**WELWYN HATFIELD BOROUGH COUNCIL
ASSISTANT DIRECTOR (PLANNING)**

DELEGATED APPLICATION

Application No: 6/2023/0527/PN15
Location: Albatross Way Hatfield Business Park Hatfield AL10 9GL
Proposal: Prior approval for the installation of 15.0m phase 8 monopole and associated ancillary works
Officer: Ms Kirsty Shirley

Recommendation: Prior Approval Required and Granted

Title:
260 PROPOSED ELEVATION

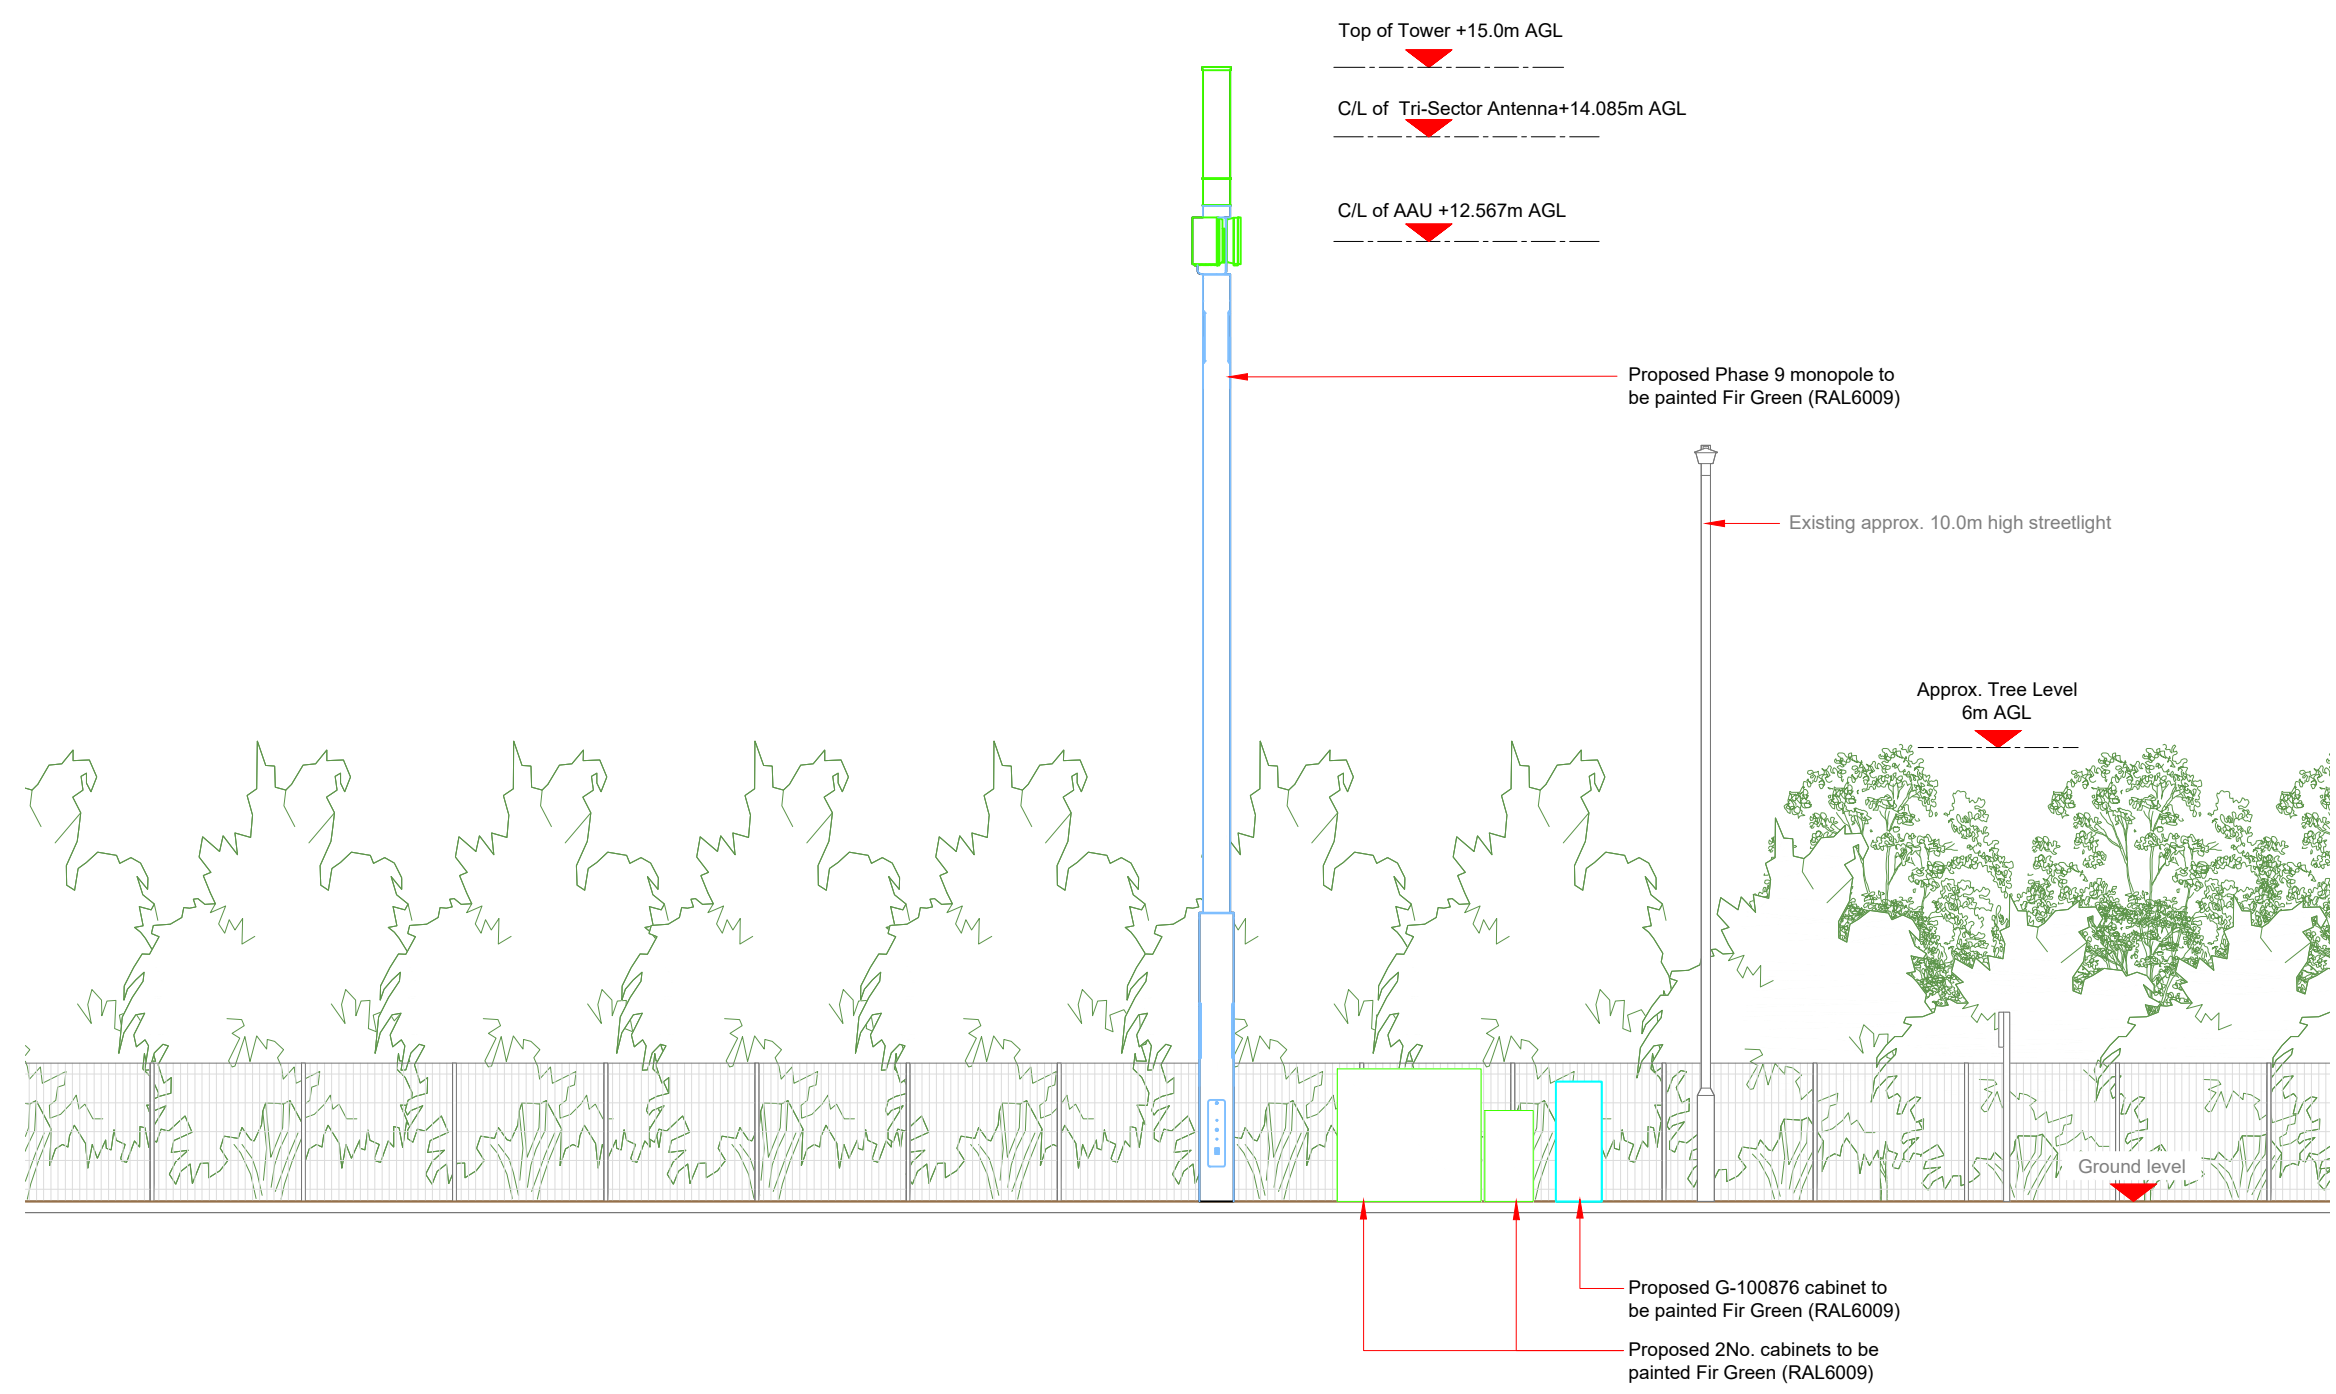
Context			
Site and Application description	<p>Prior approval for the installation of 15.0m phase 8 monopole and associated ancillary work.</p> <p>During the course of this application, the proposed mast was altered in design to be slimmer and the proposed colour and finish of the mast and ancillary equipment has been altered from galvanised steel grey to Fir Green.</p>		
Constraints (as defined within WHDP 2005)	<p>SAG - 0 - Distance: 0 SCA - 93253466.3872 - Distance: 0 PAR - PARISH (HATFIELD) - Distance: 0 Wards - Hatfield Villages - Distance: 0 HHAA - Hatfield Heritage Assessment Area(Ellenbrook Field) - Distance: 0</p>		
Relevant planning history	None		
Consultations			
Neighbour representations	Support: 0	Object: 0	Other: 0
Publicity	<p>Site Notice Display Date: 22 March 2023 Site Notice Expiry Date: 14 April 2023 Neighbour notification letter</p>		
Summary of neighbour responses	None received

The proposed mast has been located towards the outskirts of a predominantly residential area of Hatfield, in an effort to minimise any impact on visual amenity for the nearby residents. There are many streetlights in proximity to the location of the development and wider area which share similar vertical columns to the mast. Substantial vegetation is located along the east side of Albatross way, creating a backdrop the mast would be seen against. During the course of the application, amended drawings were submitted demonstrating a slimmer design for the mast and show that the mast and associated cabinets would be finished in Fir Green (RAL6009).
